Objection to Project Mars Data Centre

12 Mars Road, Lane Cove West

Submission - Objection to Project Mars Data Centre

DRAWING NUMBER  
L104

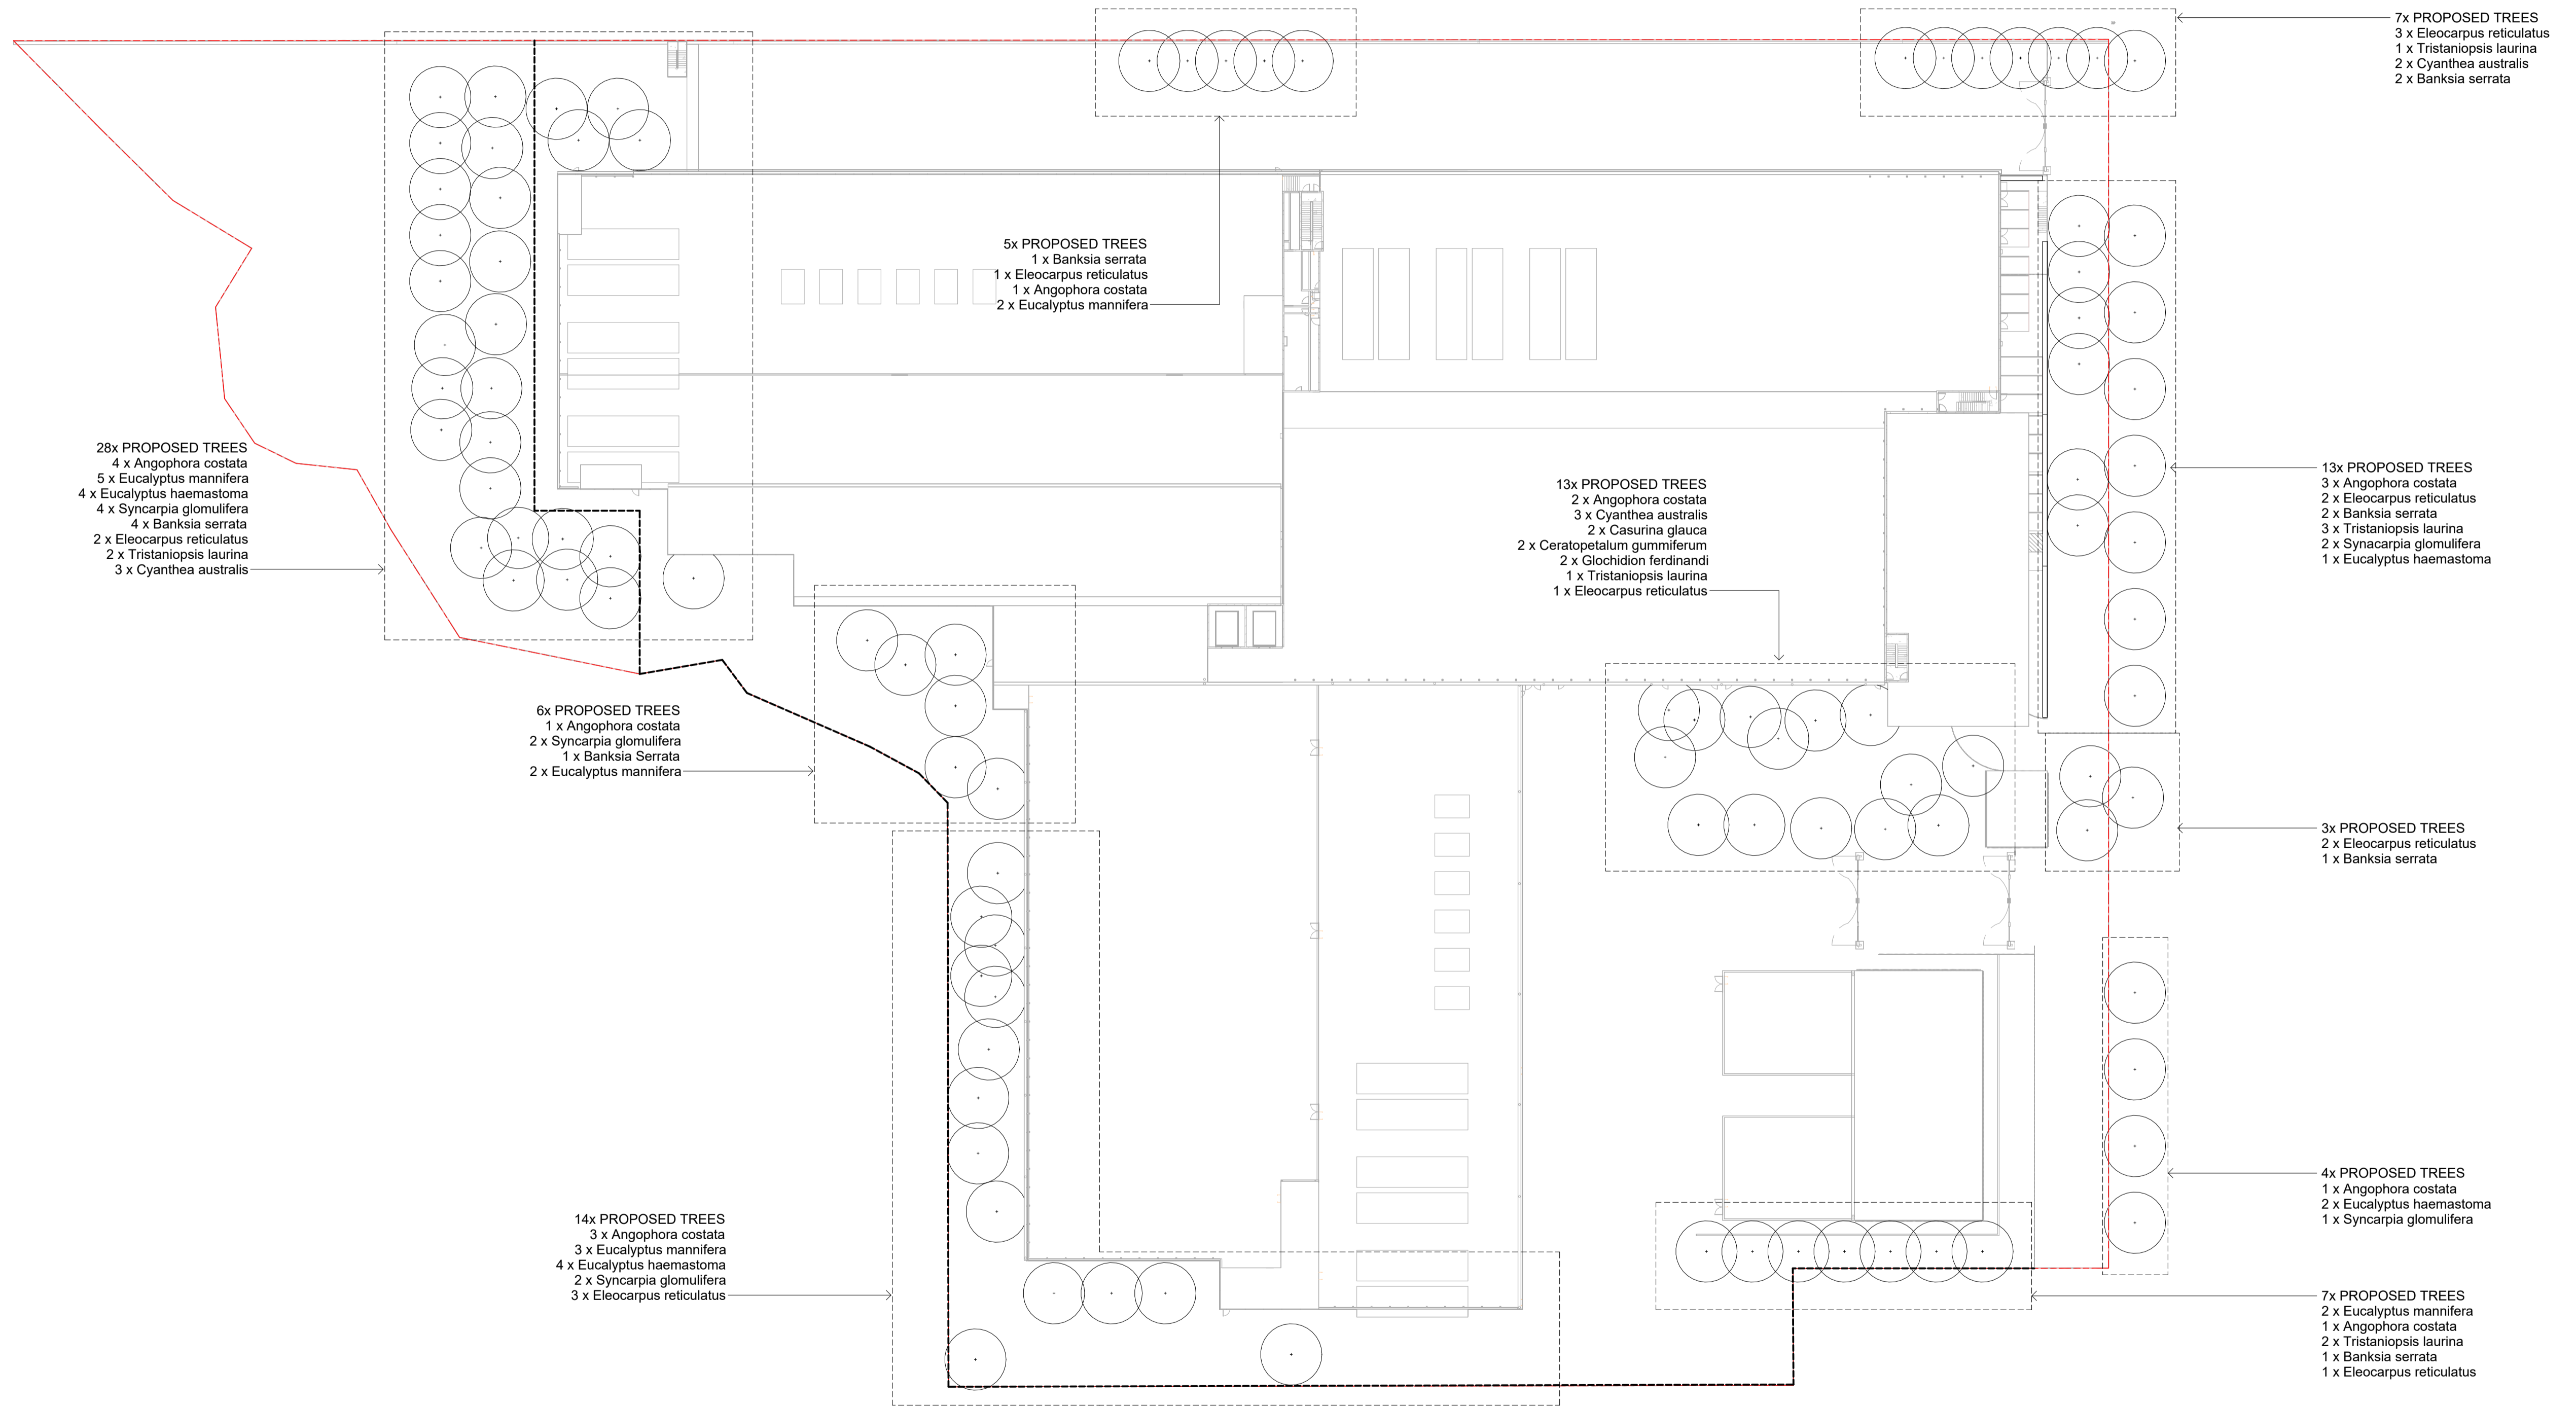
Where trees are proposed to be retained along boundaries, I am concerned about whether this can realistically be achieved given the scale of construction, excavation, building proximity, soil disturbance and likely impacts to root systems.

Also of note is the comments within the report on removal of trees that are senescing or are dead. While these trees may not be aesthetically pleasing or considered necessary in urban design, many of these trees are kept in place and are used as habitat trees. These trees should not be removed needlessly and require further investigation on the benefits of keeping them. This is particularly relevant when referring to the next section on Biodiversity.

DRAWING NUMBER  
**L105**

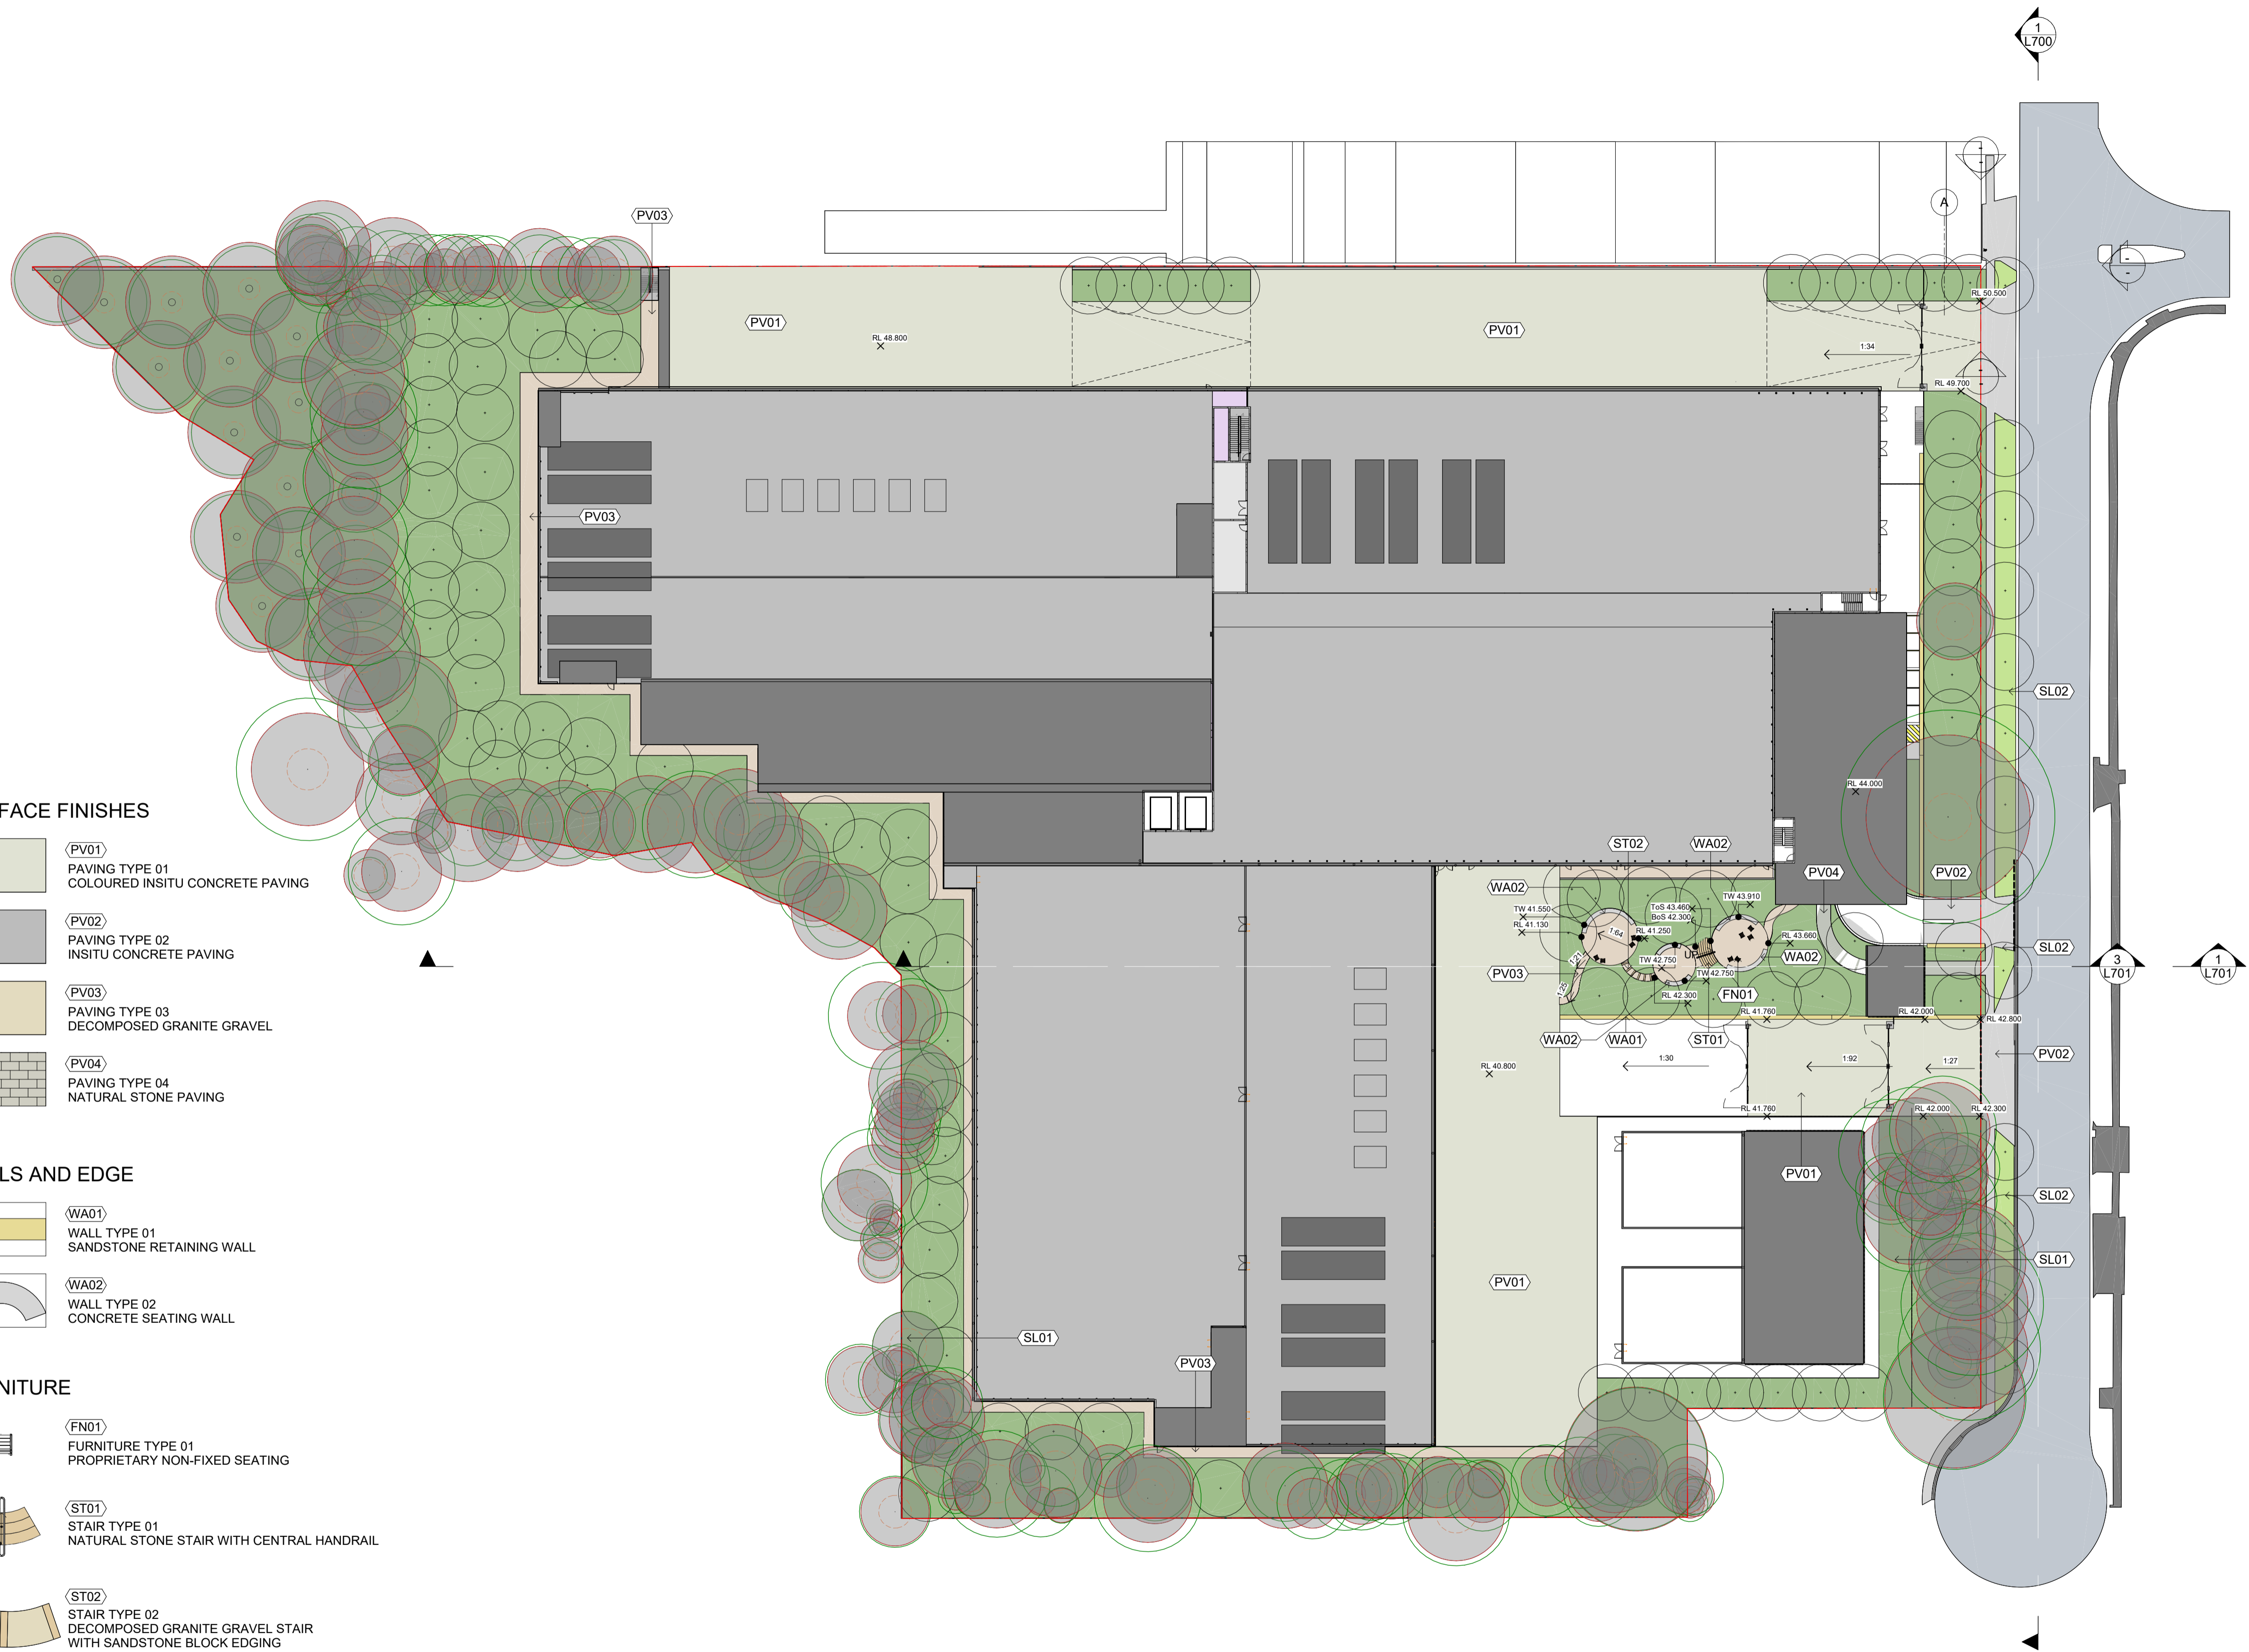
Despite this, the proposed planting palette is dominated by large canopy species (*Angophora costata*, *Eucalyptus mannifera*, *Eucalyptus haemastoma*), which:

- Do not provide **effective visual screening at eye level**
- Offer **minimal noise attenuation** from a 24/7 operational facility
- Create a **long-term safety risk** due to known limb drop characteristics

This results in a landscape outcome that is visually porous and functionally ineffective as a residential buffer.
